ADC PARKS & GREENSPACE ARBORICULTURE

PLANNING APPLICATION: FG/144/15/T

ADDRESS: East Ferring House 36 Sea Lane Ferring BN12 5ED

BRIEF DESCRIPTION: Raise crown on owners side by 2-3m, remove cross & abrasive branches, reduce back branches on south side by 2-3m & raise crown by 3-4m on south side to 1 No. Common Lime tree.

EAST FERRING HOUSE
NO: 36 SEA LANE

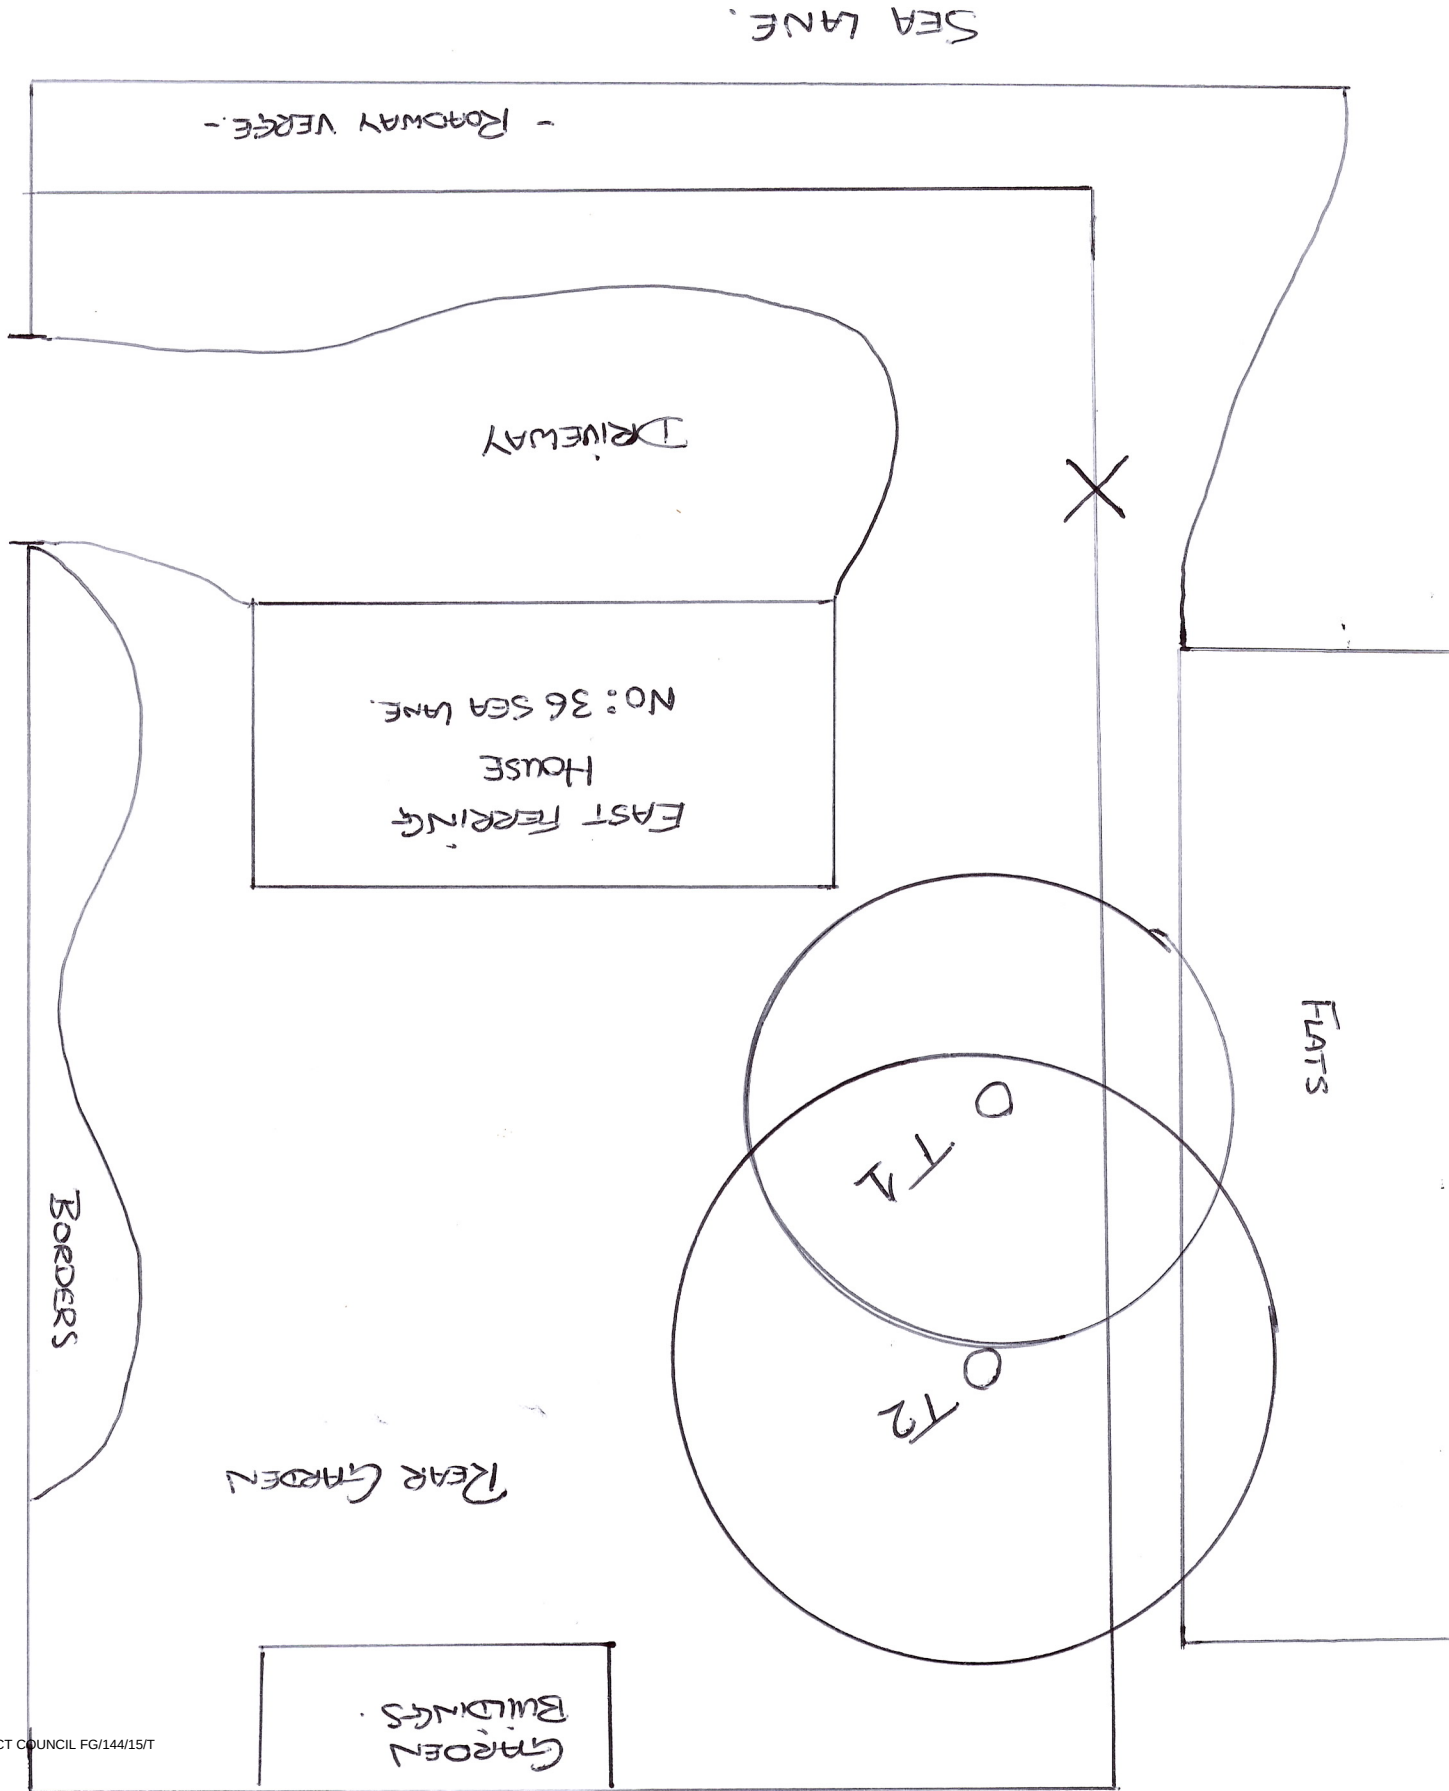
- The tree cited in this application is located in the rear garden of 36 Sea Lane, Ferring.
- The applicant has applied to Crown Raise to 3 meters to the northern aspect, reduce branches on south side by 2-3m & raise crown by 3-4m on south side.
- From the site inspection it is evident **T1** has had historic some reductions. These historic reductions do emulate the applied for reductions.

- I would have no objections to the proposed operations of crown raise on the north side by 2-3m, remove cross & abrasive branches, reduce back branches on south side by 2-3m & raise crown by 3-4m on south side.
- The following conditions must be adhered to when completing the proposed operation;

All side branches to be retained should be at least **1/3rd** in diameter of the removed branch. Pruning cuts must be flat and smooth, kept as small as possible by cutting at an optimum angle and should not exceed **100mm** in diameter.

The Crown Clean should consist of deadwood and stub removal where all cuts should be made to the branch collar. Where crossing branches are encountered the weaker branch/branches should be reduced or removed to avoid contact between them. The remaining branch/branches should be shortened as appropriate to relieve 'end weight' and sudden exposure by reducing the leaf bearing branch tips by no more than 30%.

Branches found within the clearance height having diameters greater than **100mm** should be shortened and no more than 15% of the leaf bearing growth of that branch should be removed to facilitate the unobstructed free passage of vehicles and pedestrians.
